S1.4

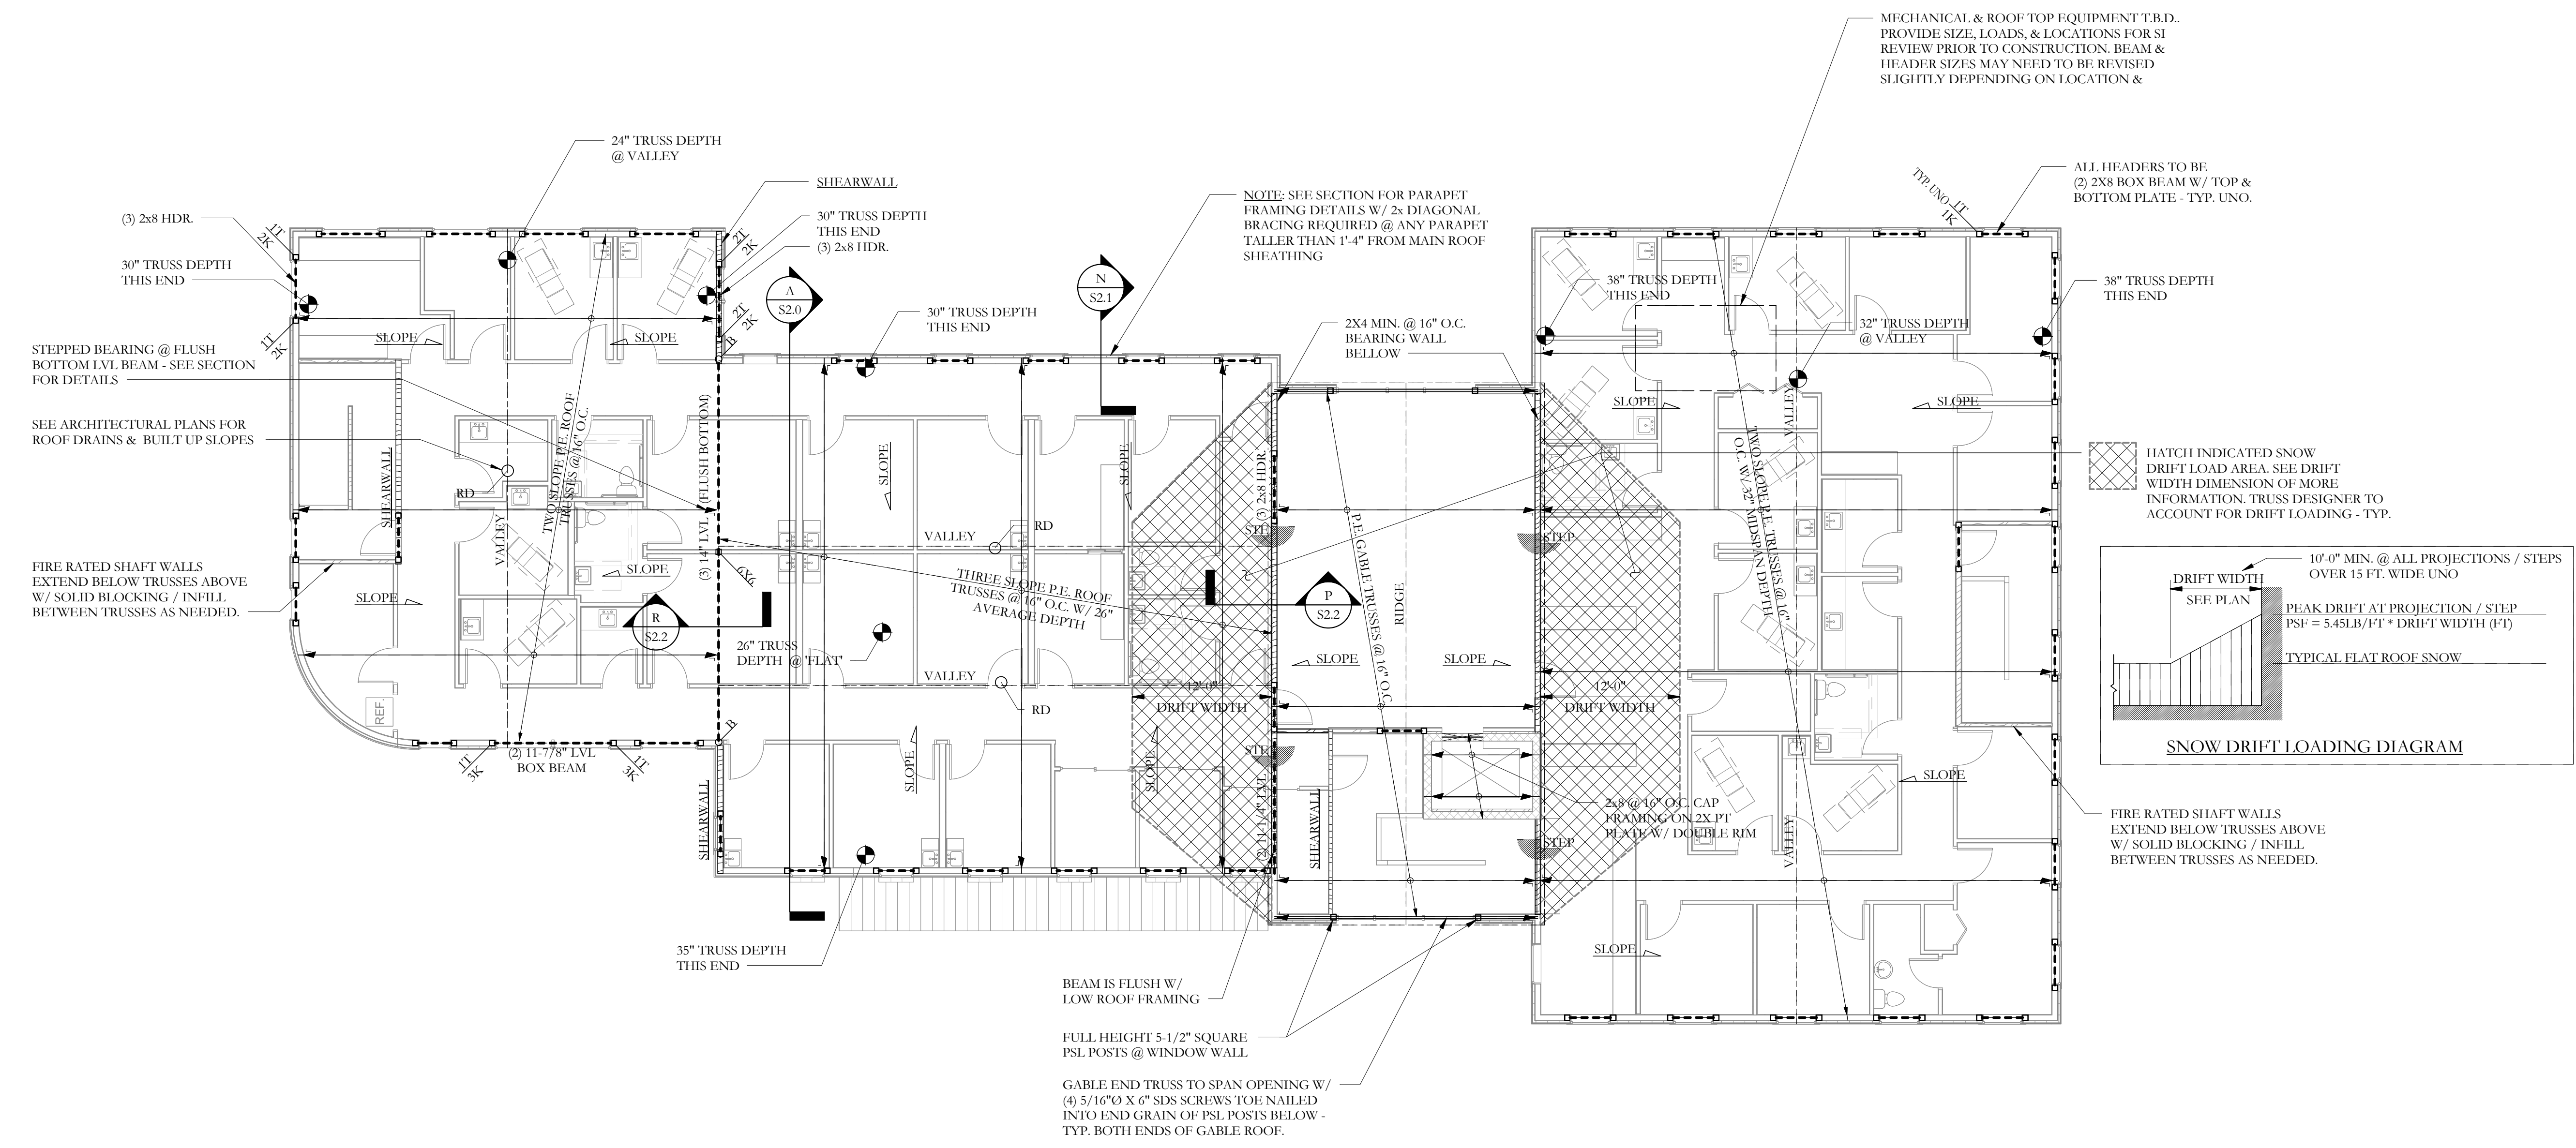
Wood Columns Acceptable for End Bearings per RFI 002, Dated 5/8/17

Wood Columns Acceptable for End Bearings per RFI 002, Dated 5/8/17

Utilize HUS210 Hangers on 18" LVL Ledger and Roof Trusses Bear on 2x6 @ 16" O.C. Cripple Wall Built of CMU Wall Below per RFI 003, Dated 5/31/17
